Public Rights of Way (“PROW”) consultation

Planning application: 2018/62/91661/E

Address: Land at Walkley Terrace and Brunswick Street, Heckmondwike

Proposal: **Outline** permission for residential development and facilitating engineering operations **and full** planning permission for access and spine road

| Drawing Title:  | SITE PLAN - OPTION 4 AS PROPOSED                                 |

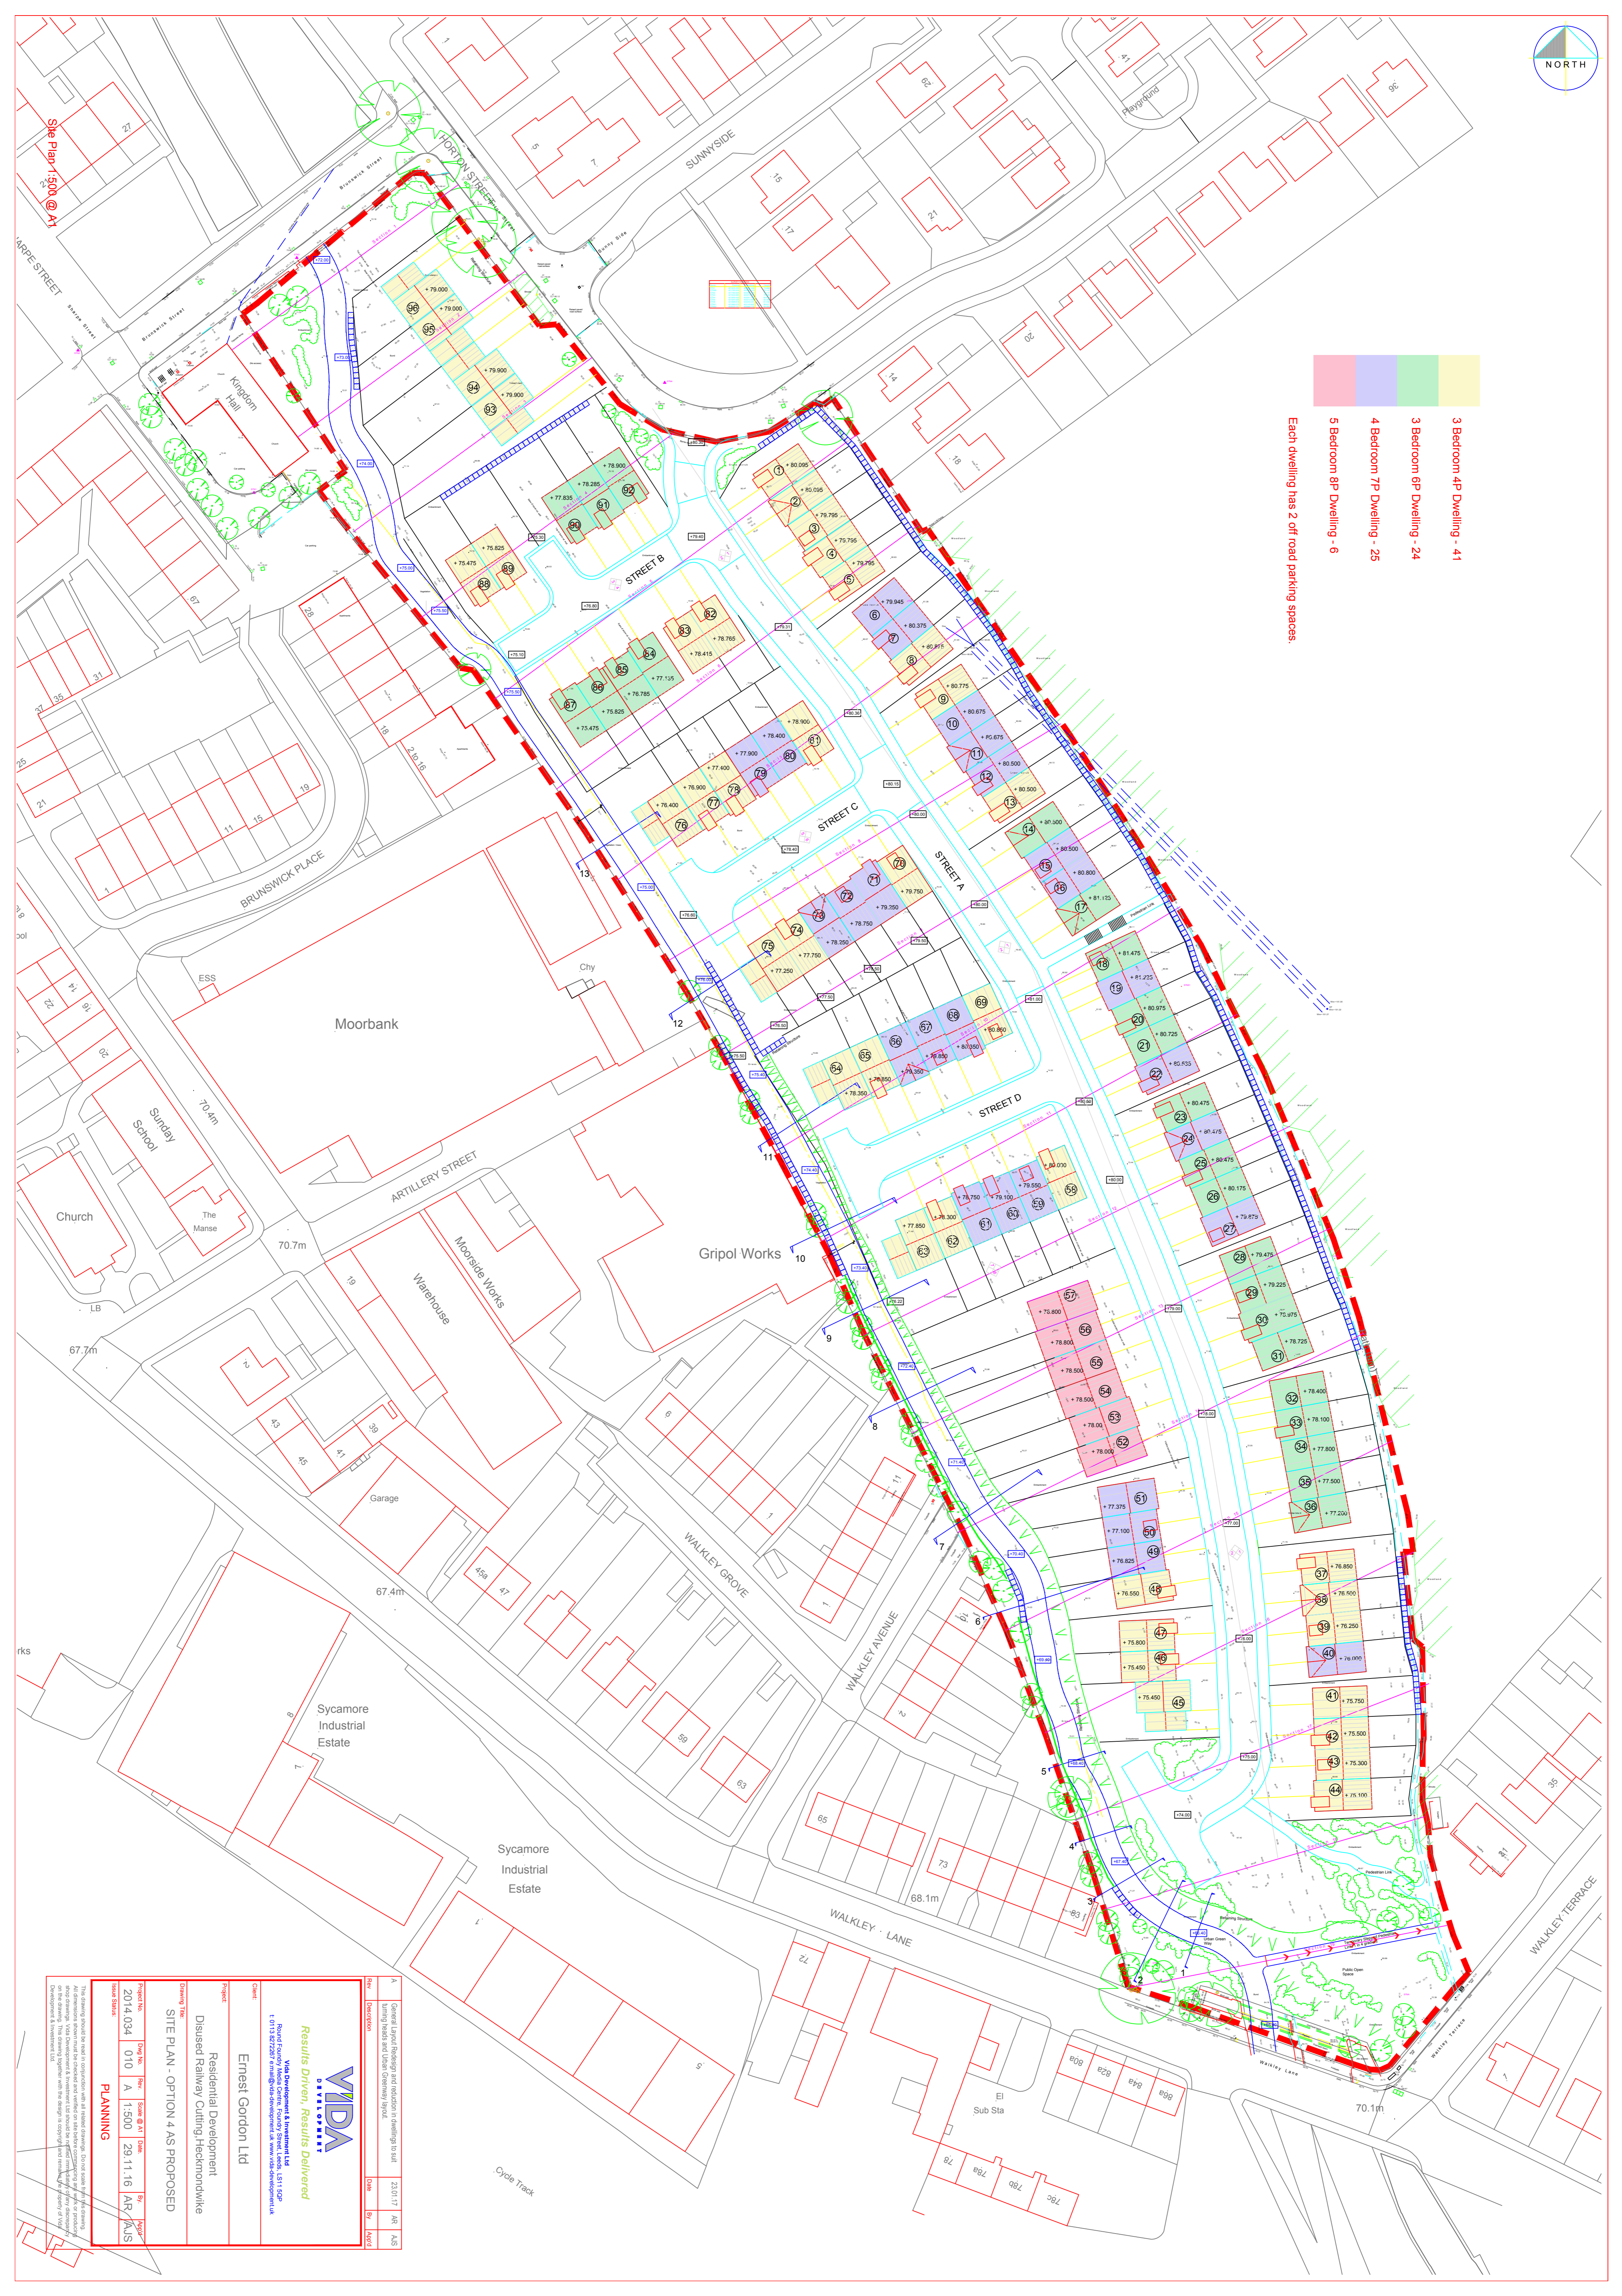
The application makes no greenway/multi-use provision.

Two indicative routes at either end of the access and spine road are shown and identified as being provided by “others”. Both are too narrow and steep for multi-use, with one including multiple flights of steps.

Public access over an appropriate, dedicated motor traffic-free route is expected by PROW to be proposed and provided. If such provision is not appropriate at outline application, then a condition for the submission and agreement of a scheme to provide such a route is requested. Please note that full permission is sought for the access and spine road, in the current application submissions this is considered entirely inadequate to serve as a link as identified in the UDP, and is not currently demonstrated to be compatible with provision of an appropriate link.

Section 8

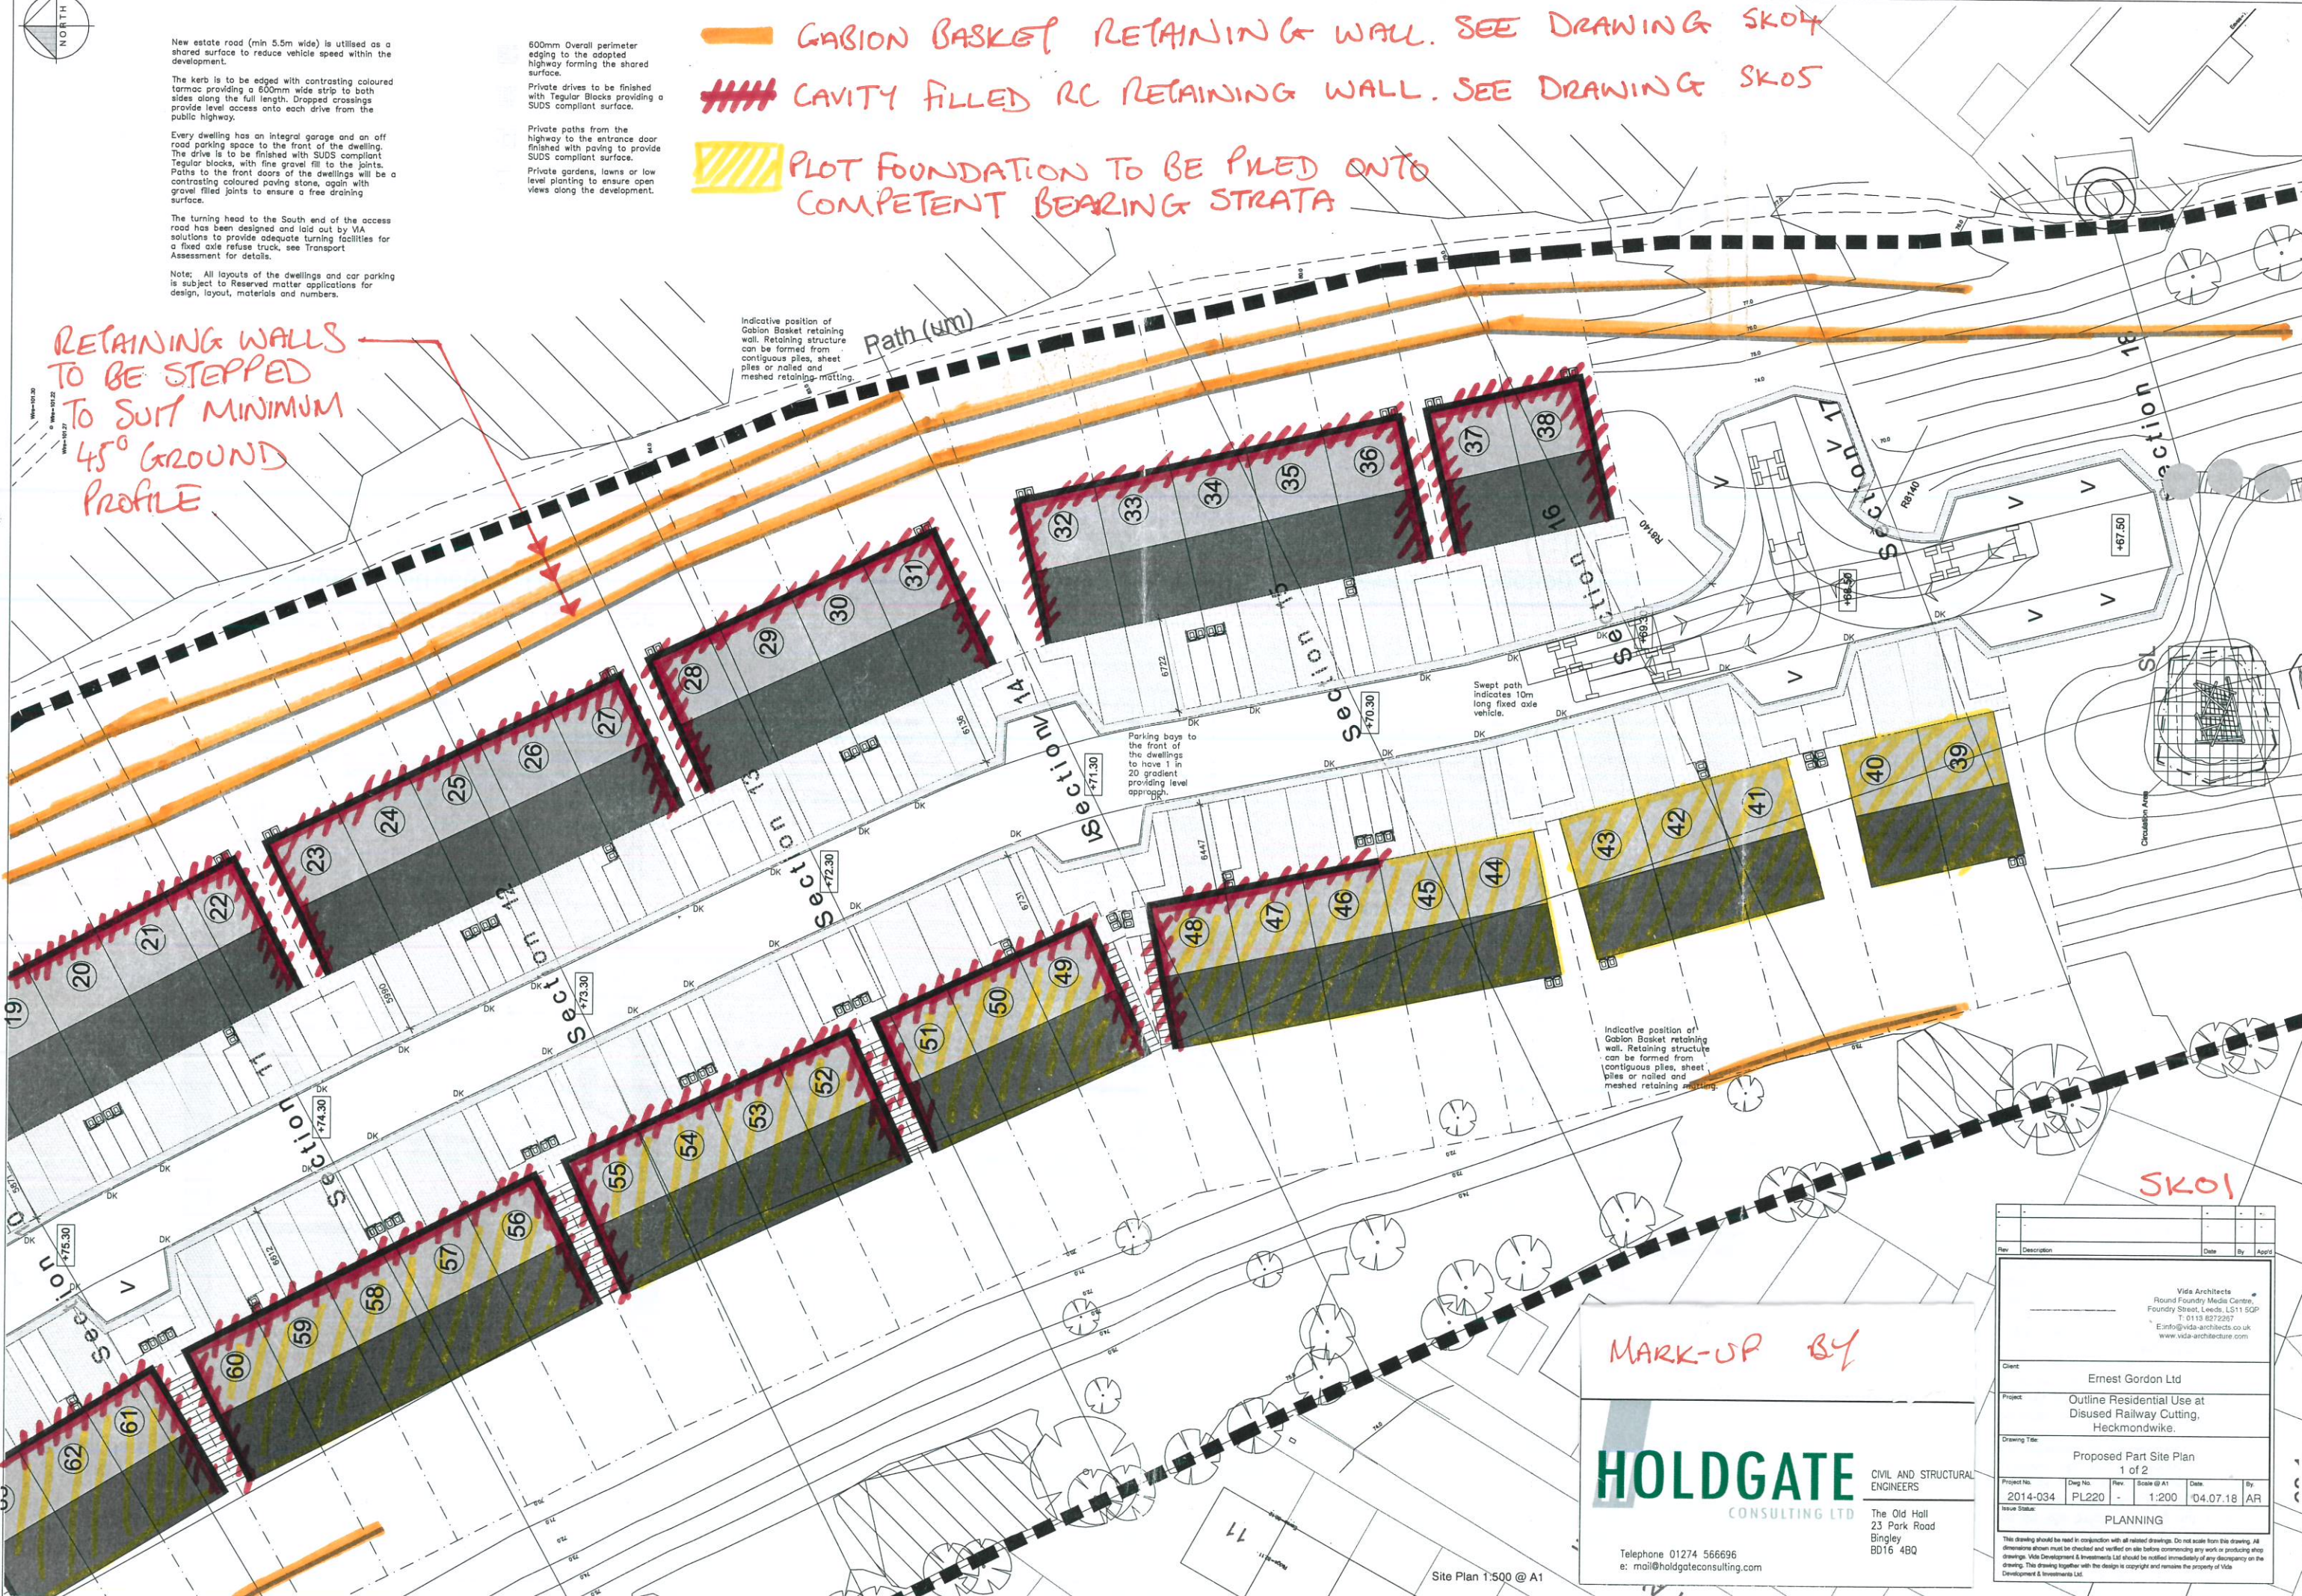
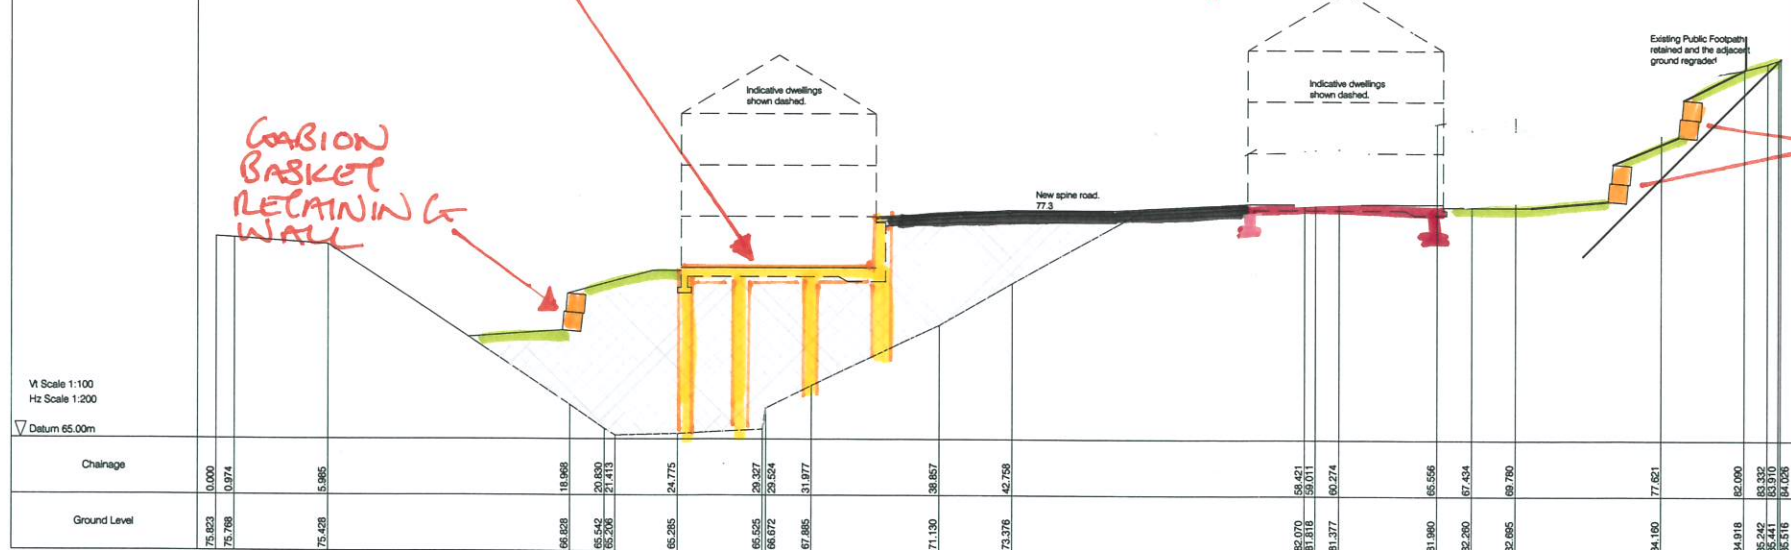
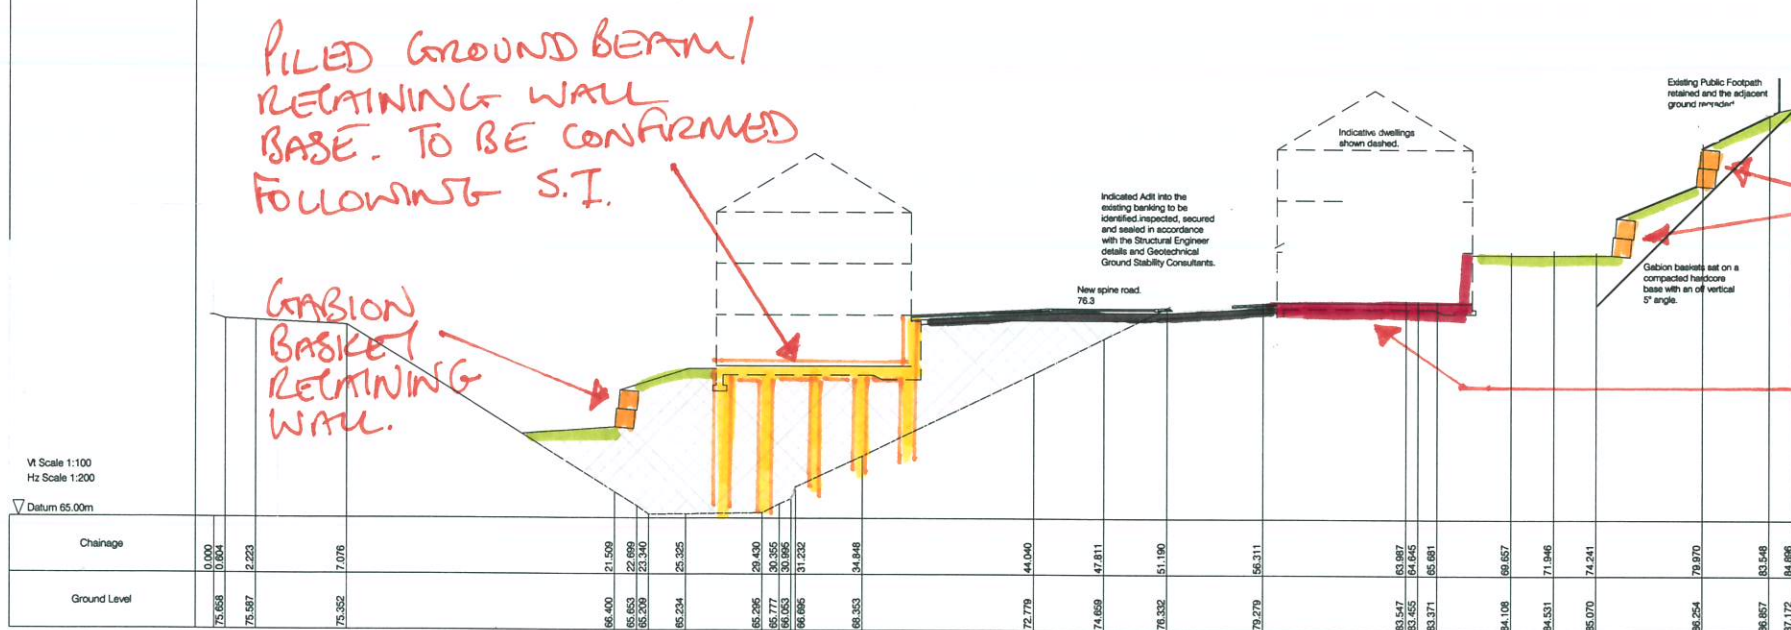
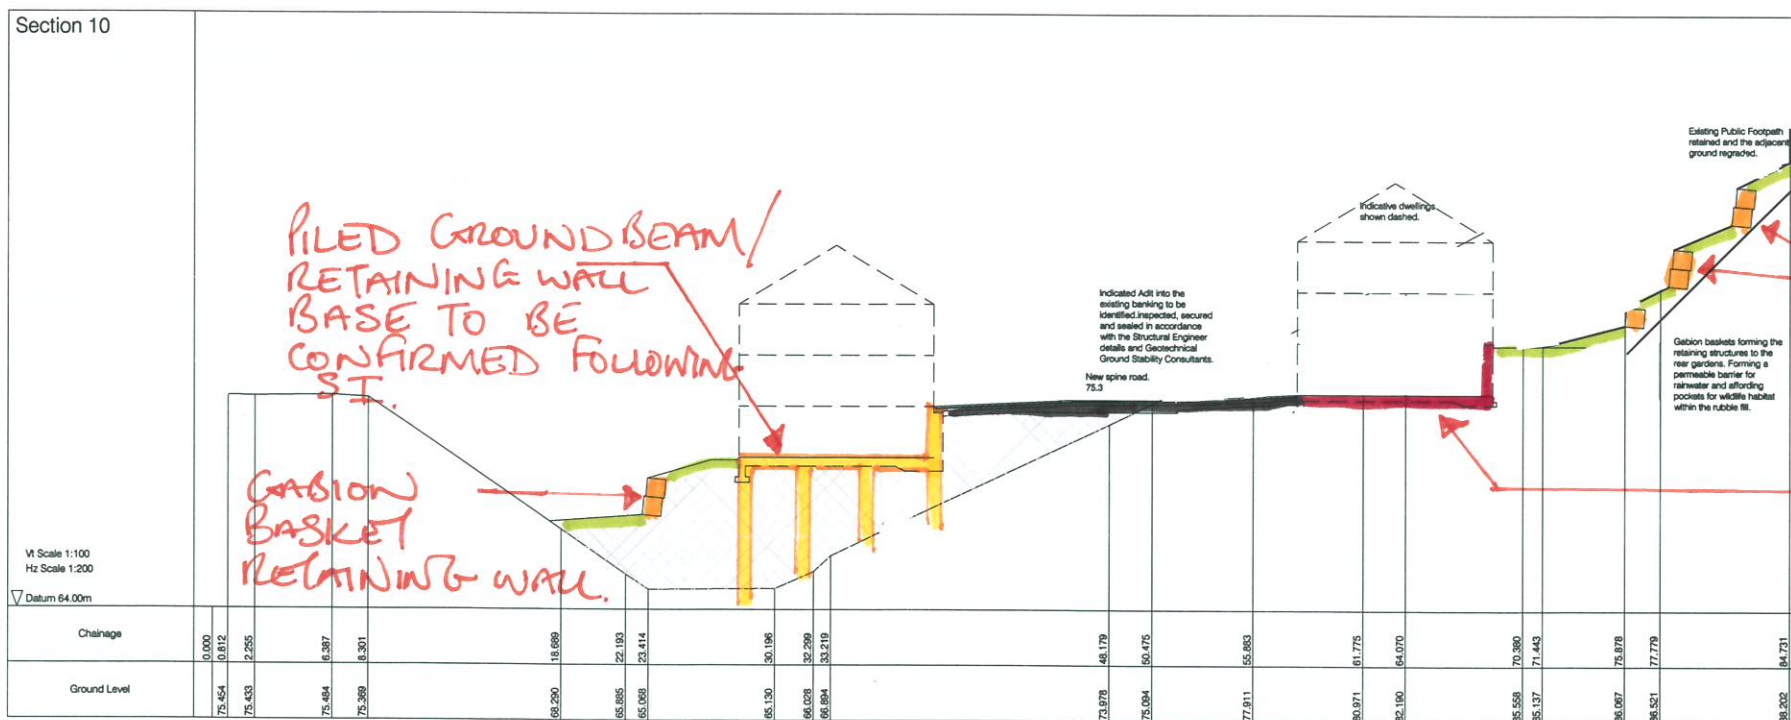
The major proposed retaining works should also attract a pre-commencement condition relating to the proposed details of design and construction, requiring a scheme to be submitted to the LPA for the requisite agreement of highways structures.
